30 MAY 2012	
FOR THE ATTENTION OF

Martin Nugent  
01254 828060  
D3/12/0317

**Planning Application, Ribble Valley District  
3/12/0317 Pendle Hotel, Clitheroe Road, Chatburn**

ROOF PLAN scale 1:200

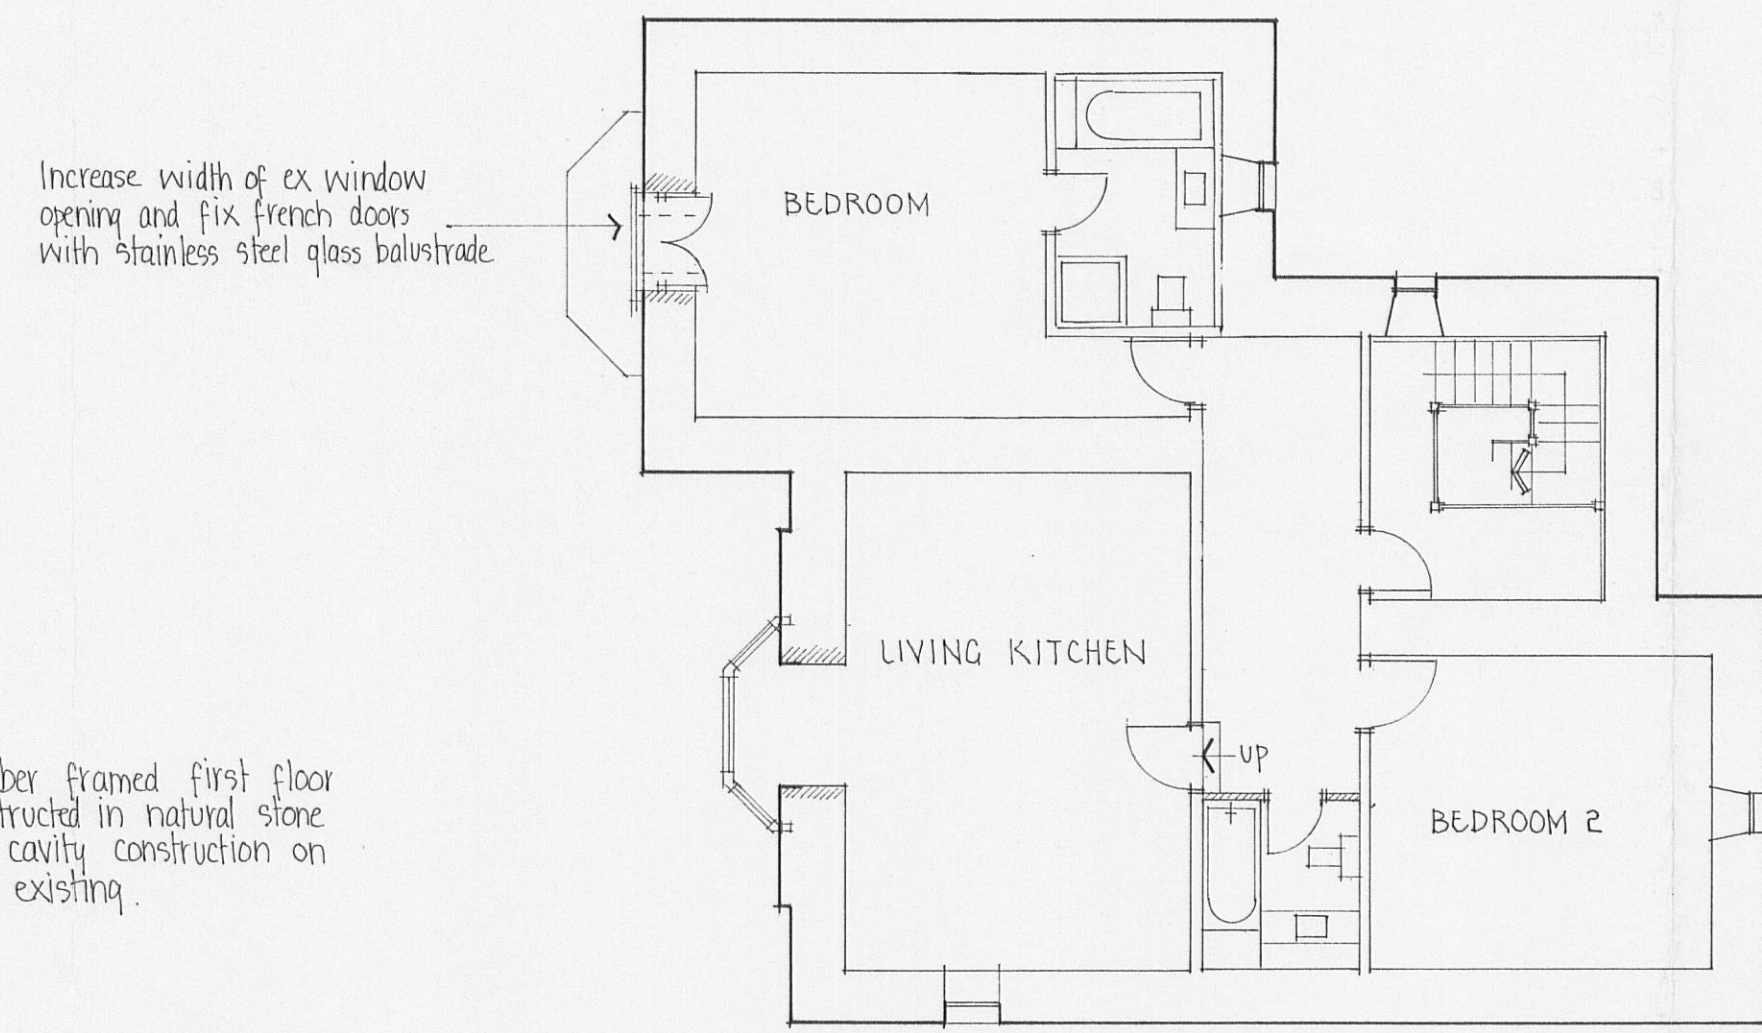
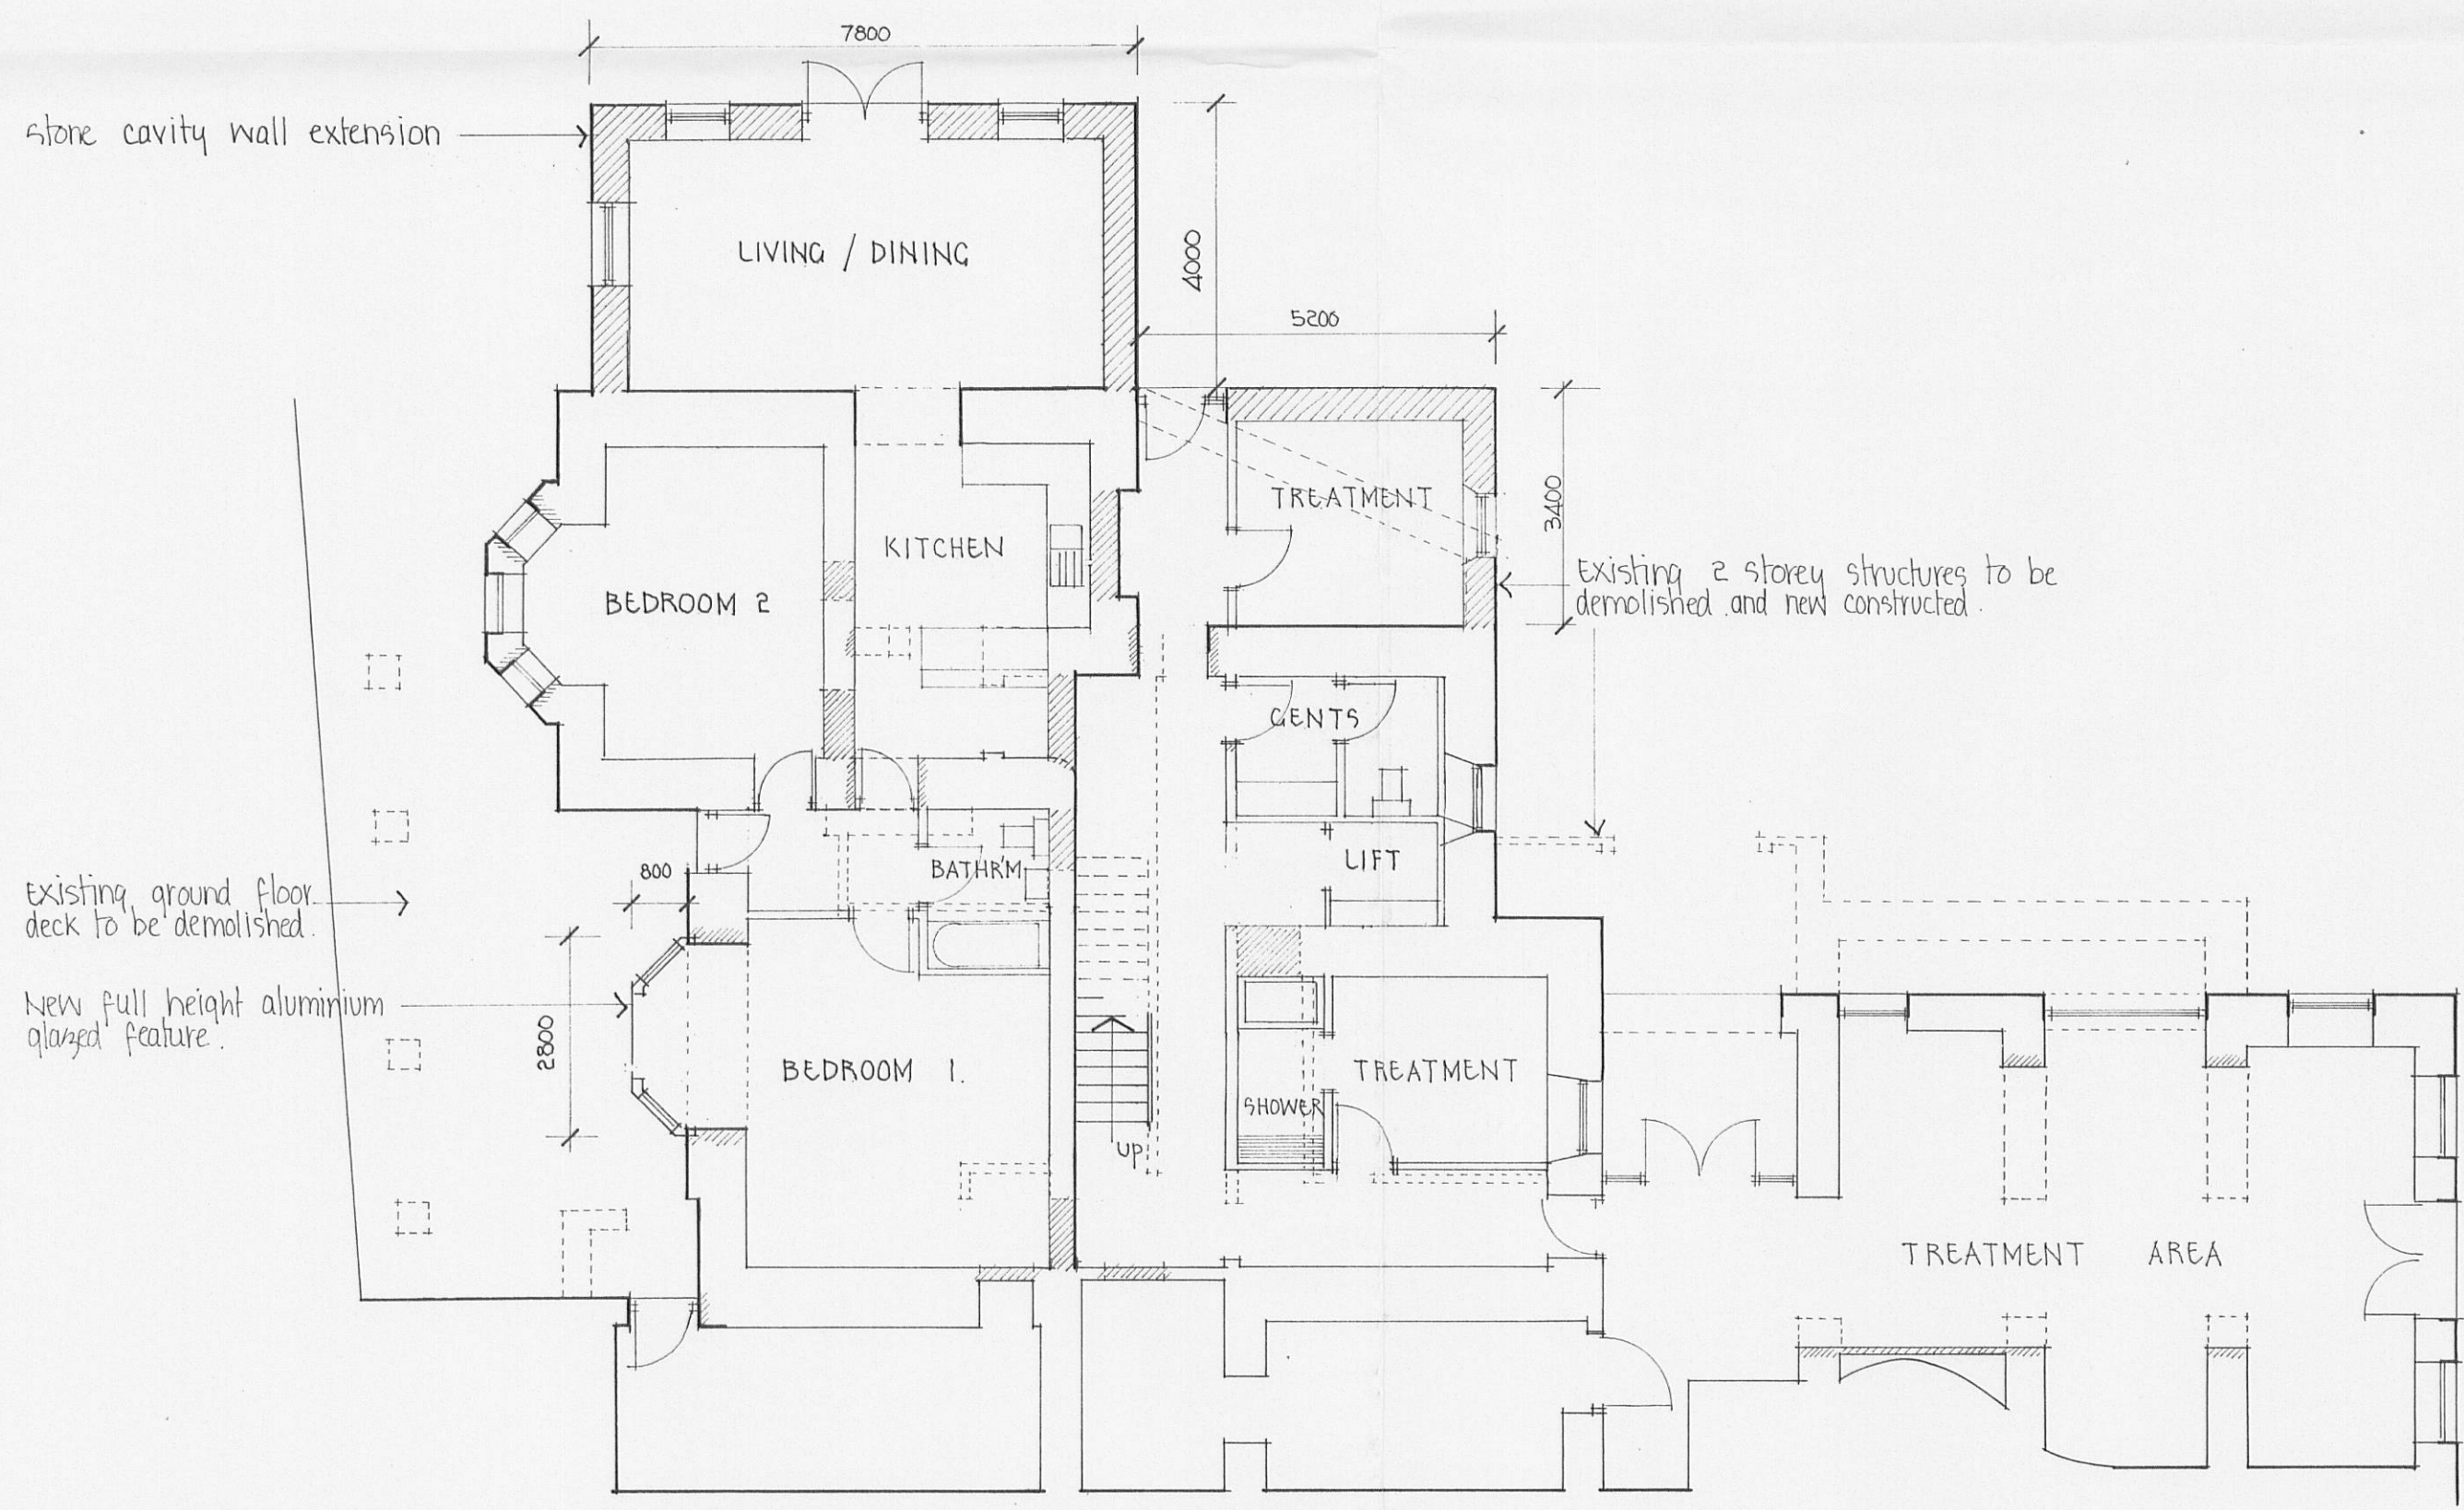
The site plan identifies 16 car parking spaces within the site. This provision is considered appropriate for the anticipated residential and commercial use envisaged within the development.

However, it is clear that there is a substantial parking area available and that this offers considerable scope for use by additional vehicles. Where previously there was benefit in having a manoeuvring area available, this requirement is not necessary for the proposed uses. I have no specific recommendations for this area but would suggest that a more sympathetic treatment should be considered rather than perpetuating a large area of under-used car park.
